Application no: H02-0496-11

Location: Martins Farm
Postland
Crowland
Peterborough
PE6 0JU
PE6 0JU

Amendment: Amended design details (dwg. nos. 300-07-16, -02B, -03A, -04B, -05B, -08A, -09B, -12B, -15A)

Re: Martin's Farm, Postland, Crowland – Your Ref: H02-0496-11 – Conversion of barns into two residential dwellings

Scale: 1:10 Date: 17.01.11
Drawn: AJC
Drawing Title:
Window & Screen Details
Drawing No.
300-07-08 Revision **A**

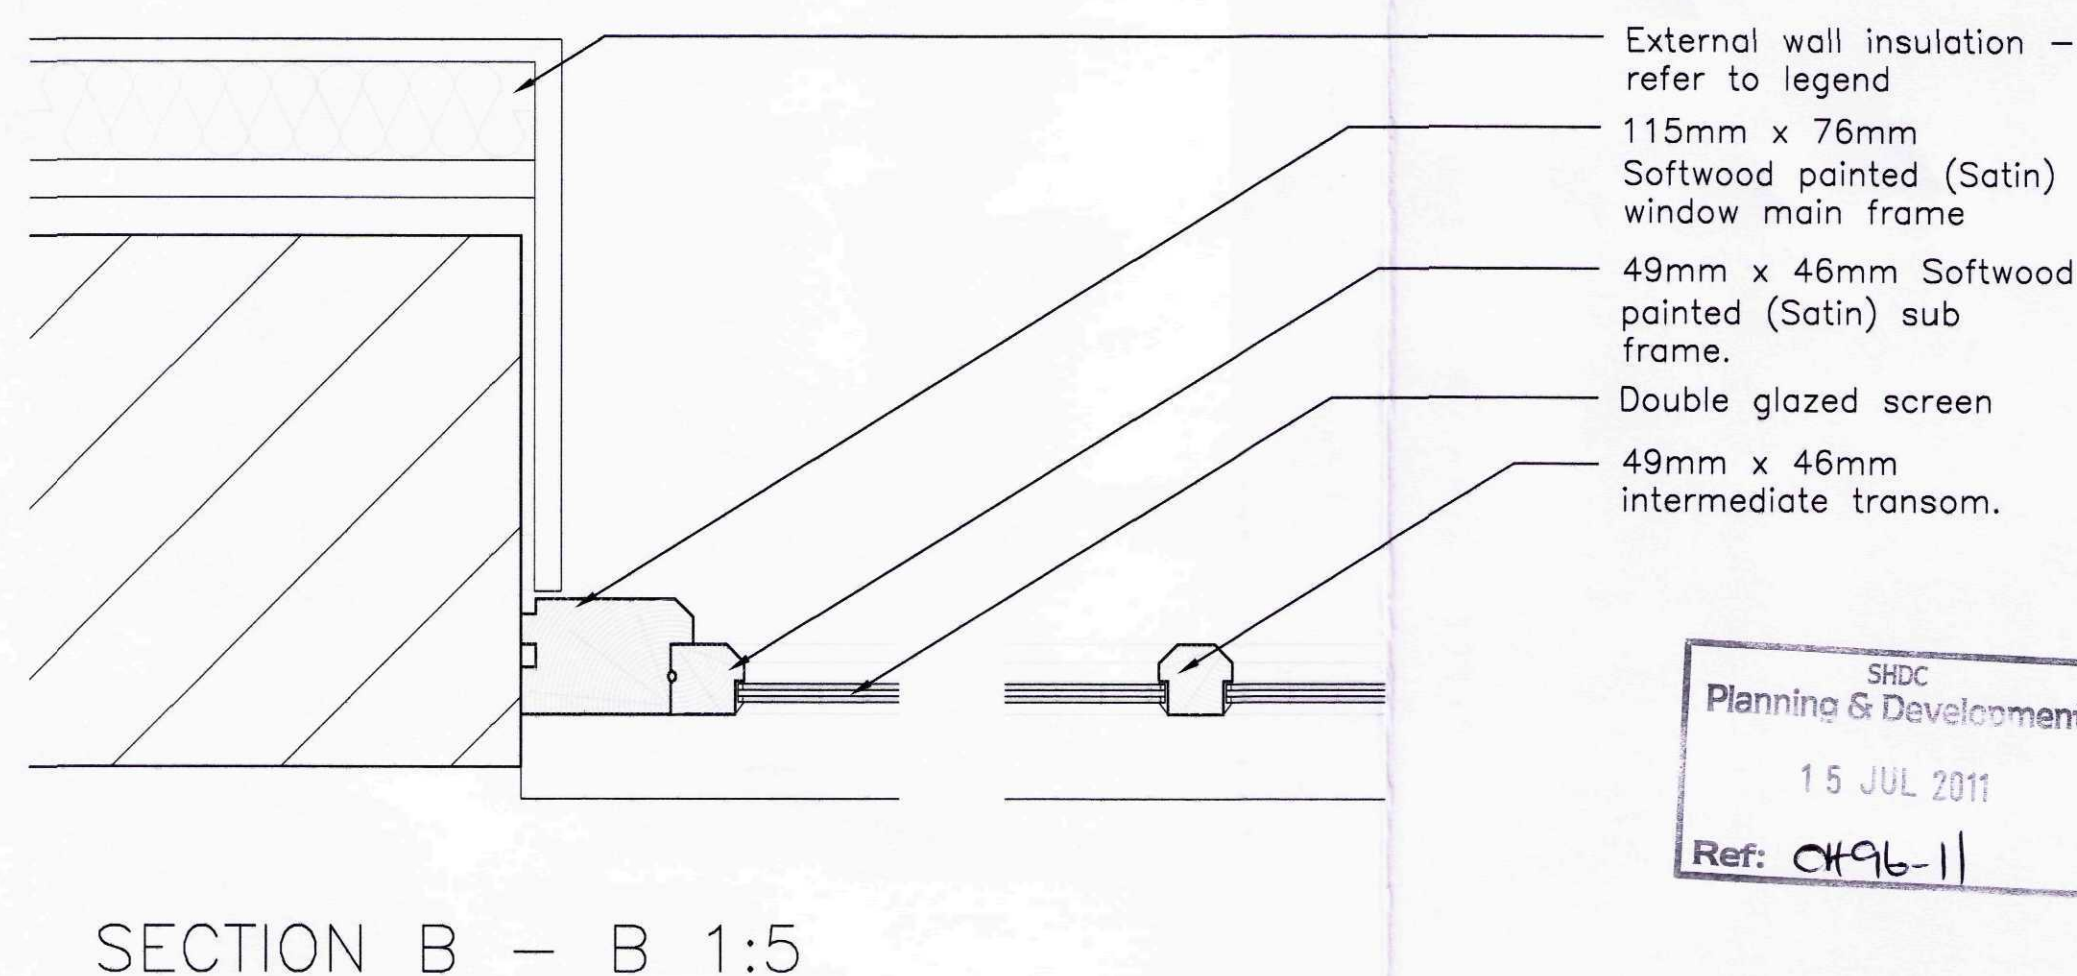
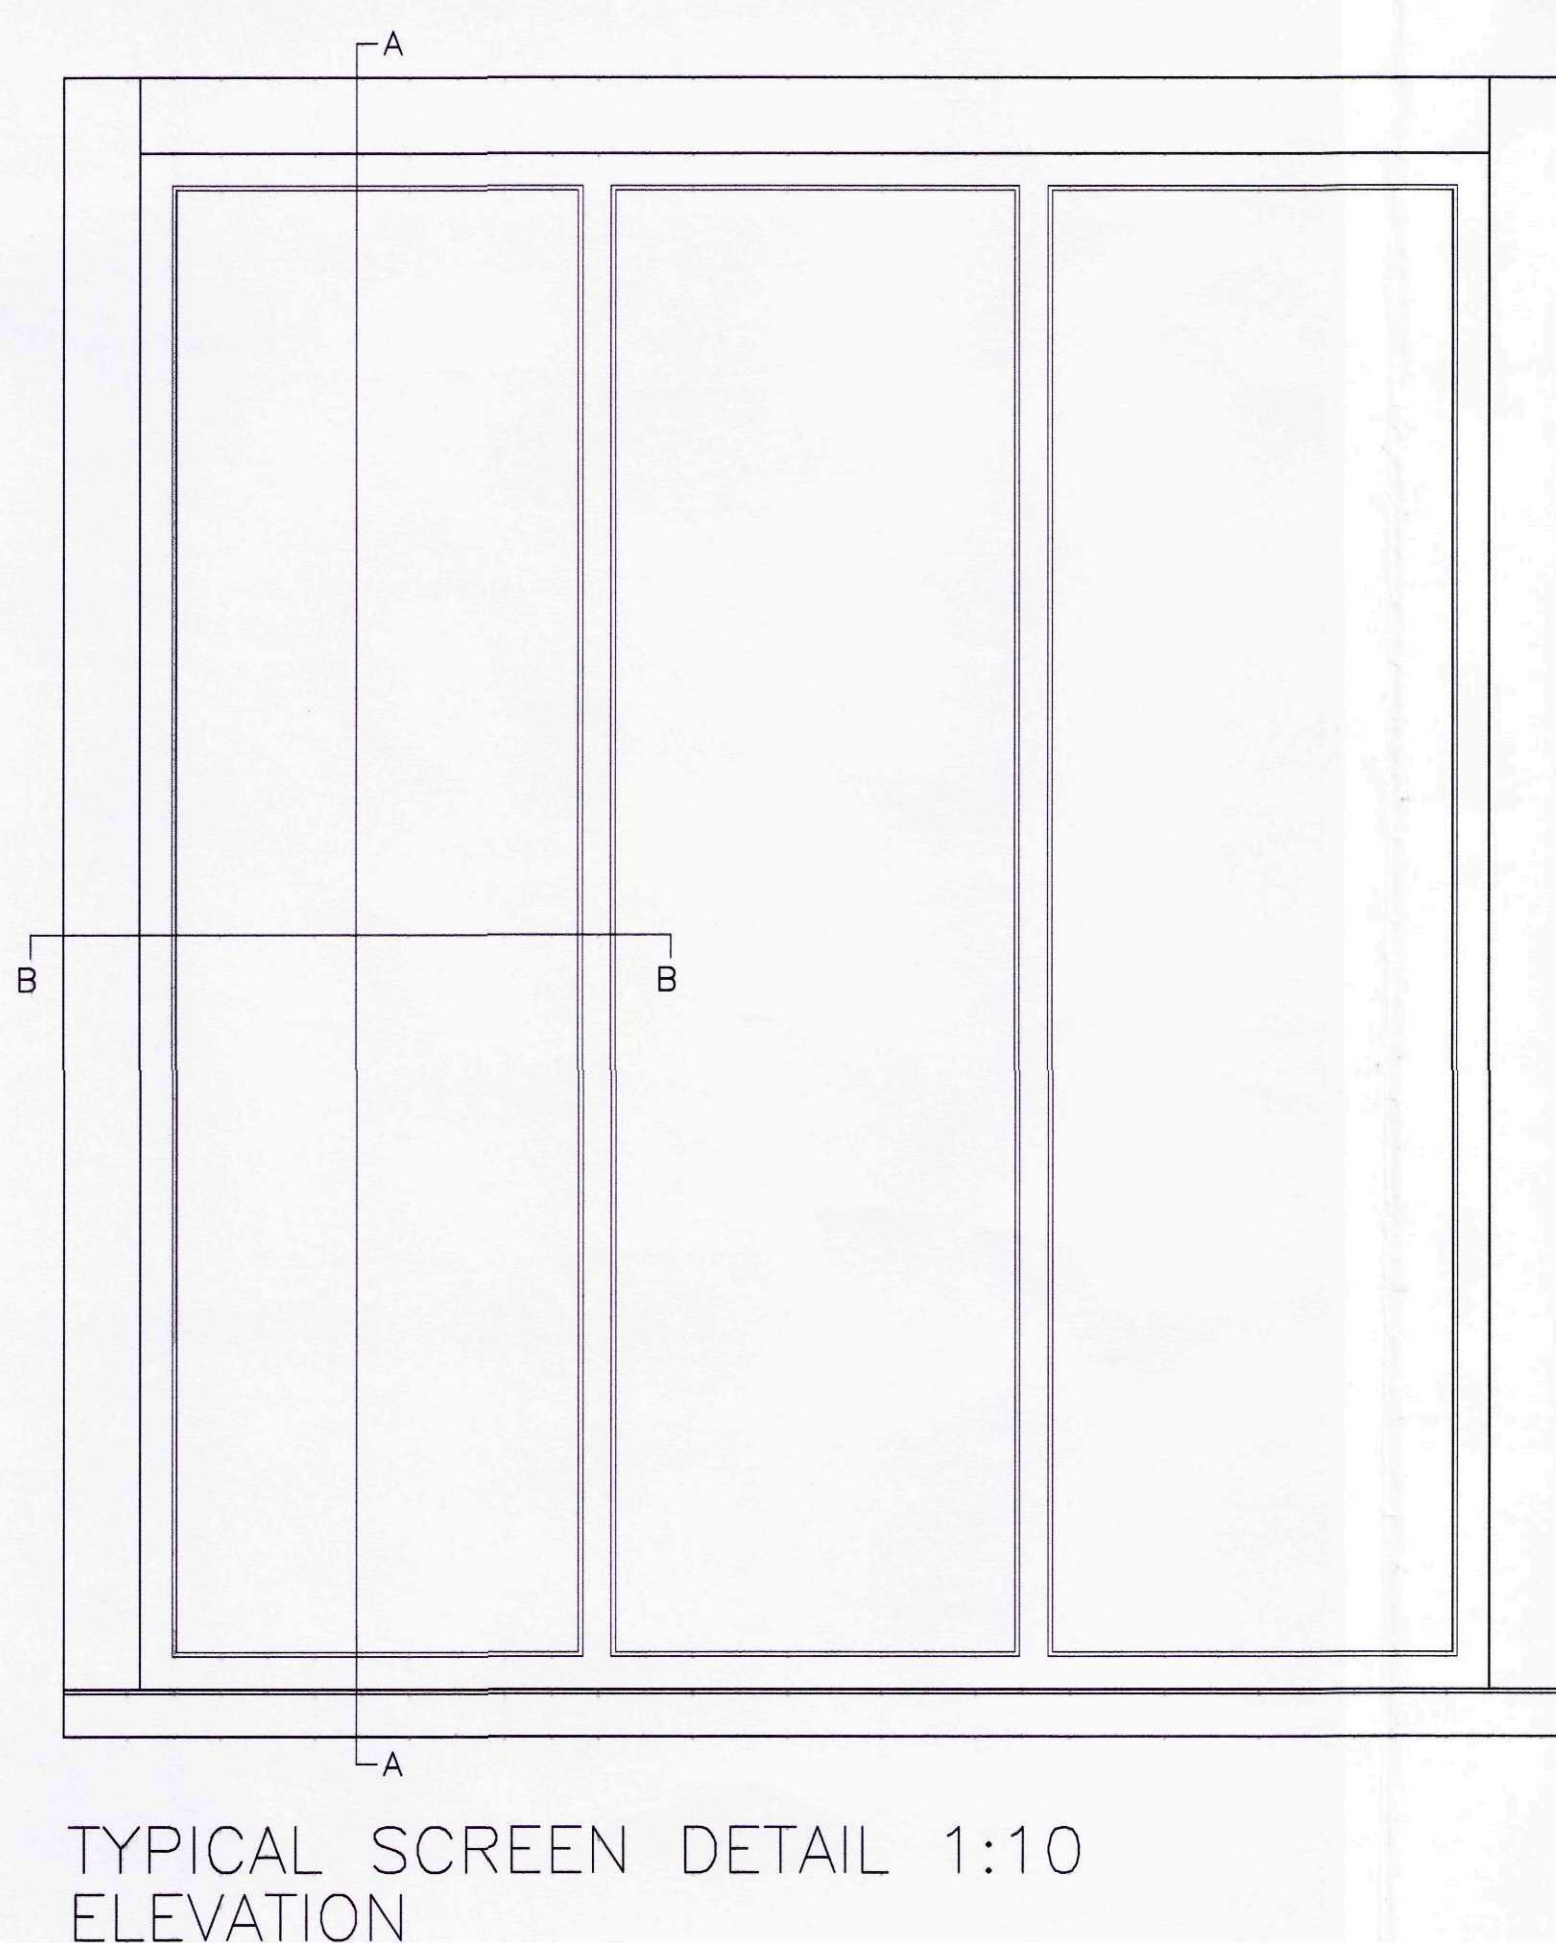
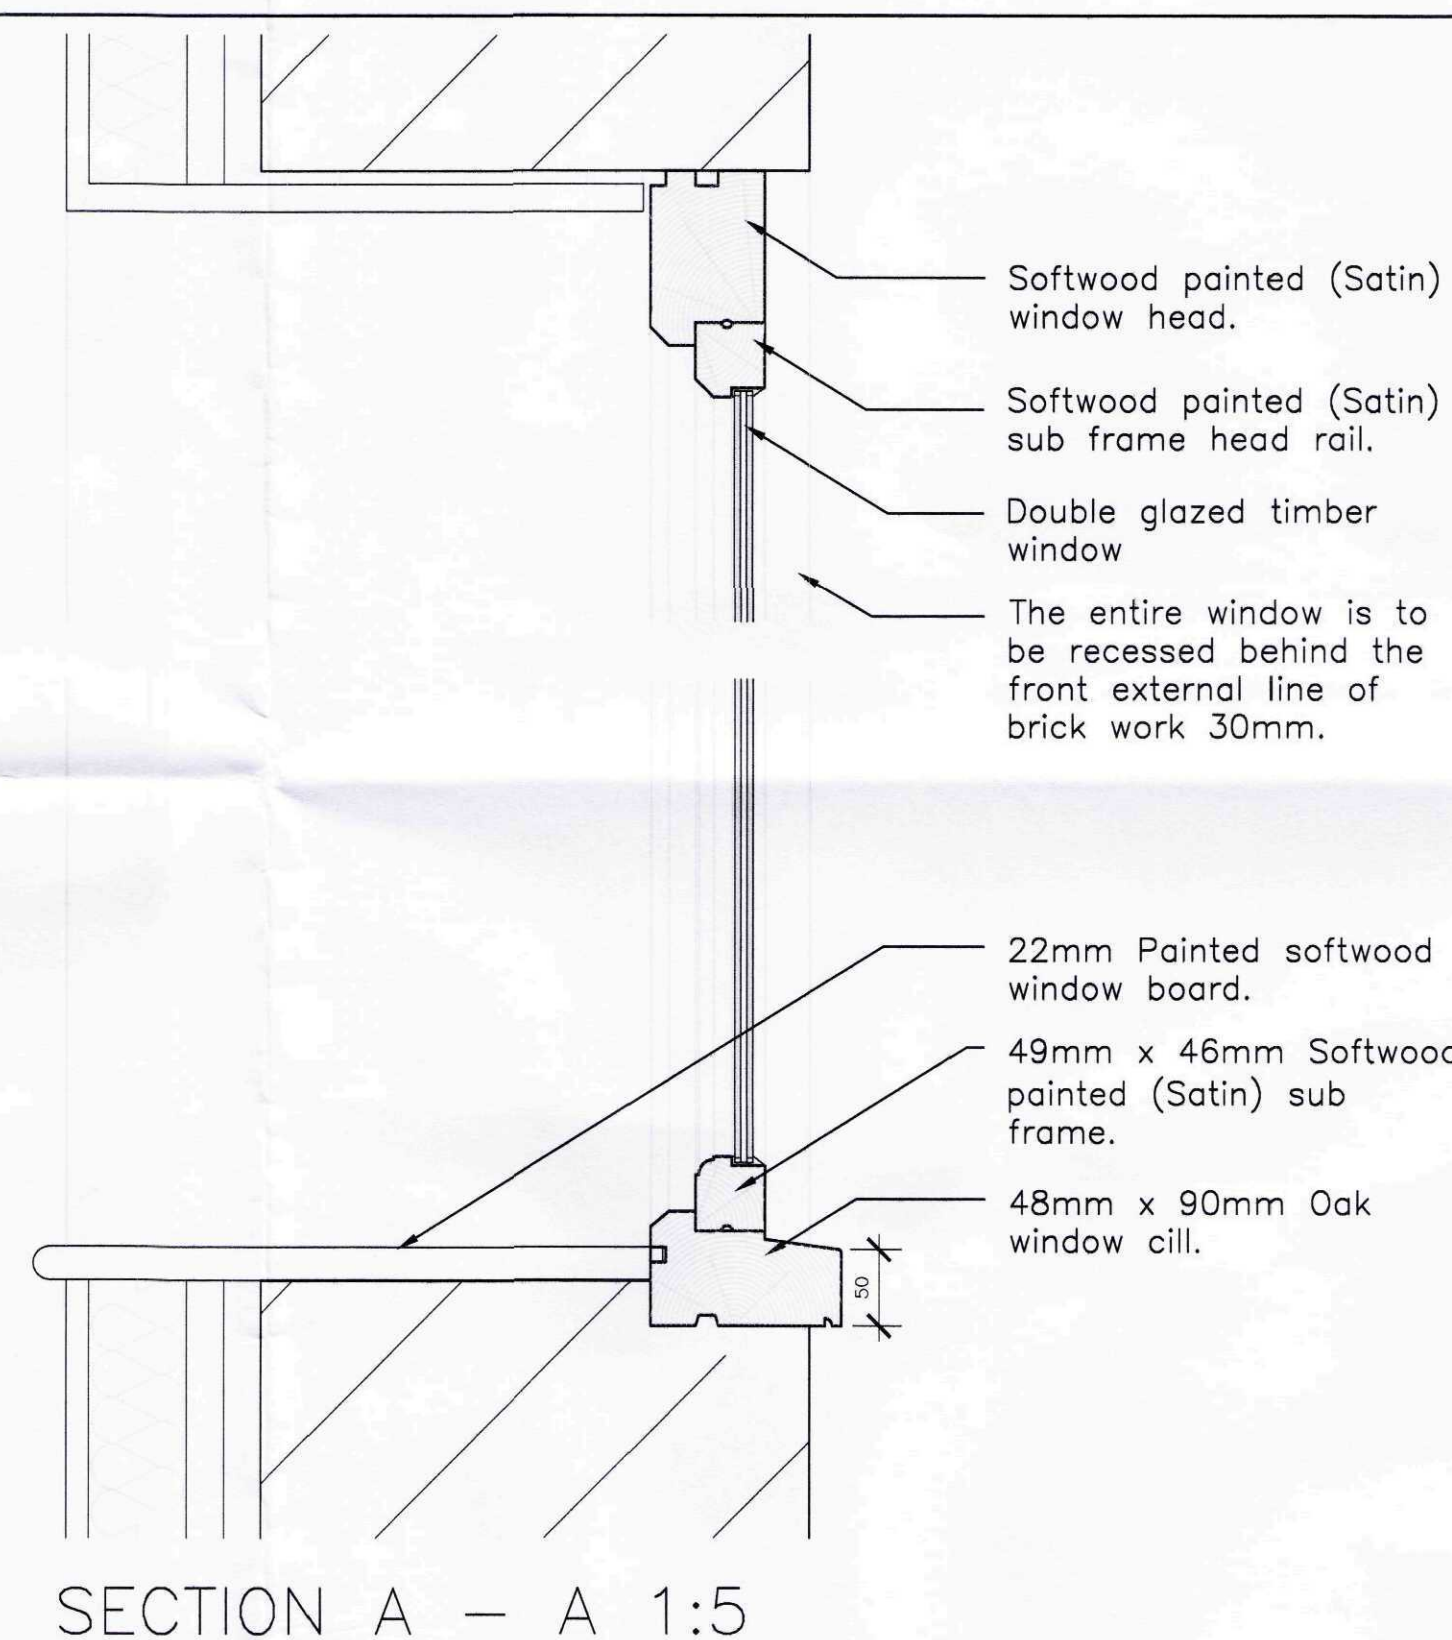
With regard to the windows, please refer to the enclosed revised plans and detail drawings.
